Subject: Emprise Storage Rezone (CS222)

The Community Services Department has reviewed the Emprise Storage Rezone application and is providing the following preliminary comments of behalf of El Paso County Parks. This application and the following comments and recommendations will be presented to the Park Advisory Board for endorsement on October 12, 2022:

This is a request by Land Development Consultants, on behalf of Emprise Acquisitions LLC Hagen to rezone 34.52 acres from RR-5 (Rural Residential) to CS Commercial Services District for a commercial use classification for RV, boat and vehicle storage and future mini-warehouse storage units.

REZONE MAP

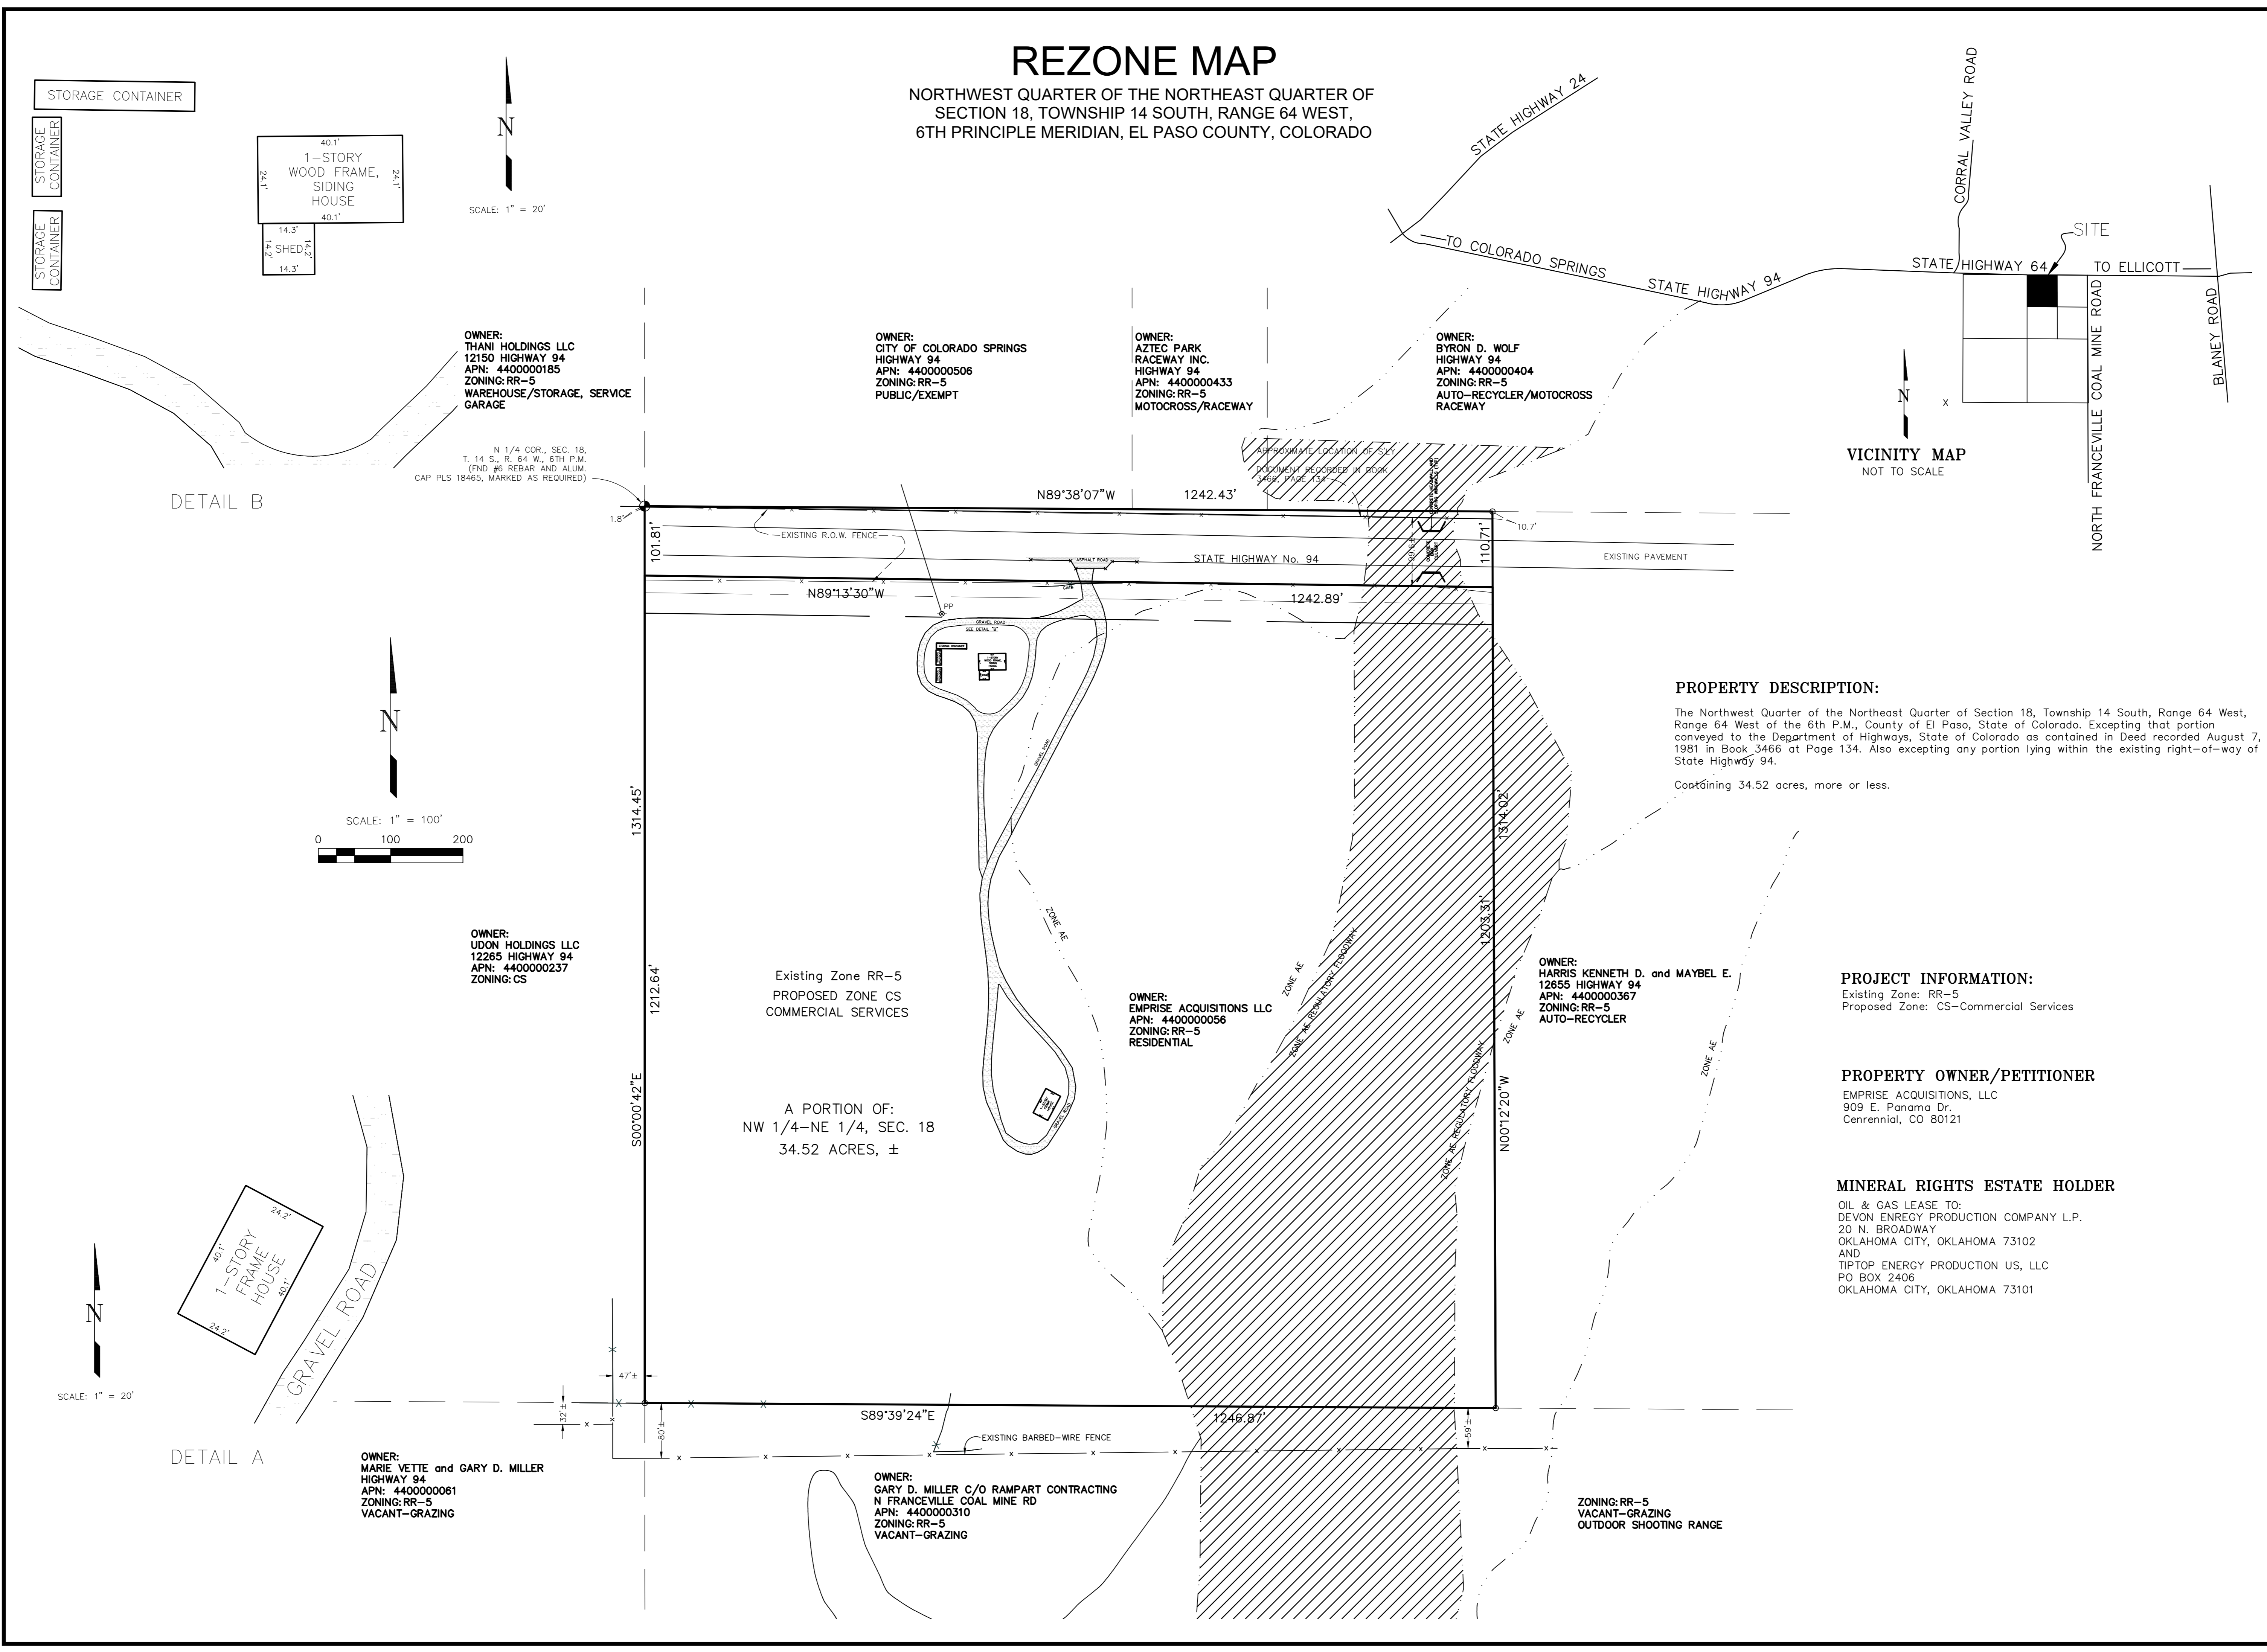
Parks staff provides notice that the Highway 94 Primary Regional Trail is planned for 25' south of the right of way of Highway 94. As it pertains to this application, the County encourages that the landowner provide a 25-

foot-wide public trail easement along the south side of Highway 94 that allows for the construction and maintenance by El Paso County of the Highway 94 Primary Regional Trail.

Staff recommends that the Planning Commission and the Board of County Commissioners include the following conditions when considering and/or approving the Emprise Storage Rezone: (1) designate and provide to El Paso County a 25-foot-wide public trail easement along the south side of Highway 94 that allows for the construction and maintenance by El Paso County of the Highway 94 Primary Regional Trail, and dedicate the easement to El Paso County. (2) No regional park fees are recommended, as the Board of County Commissioners has elected to not require park fees for commercial land use applications.
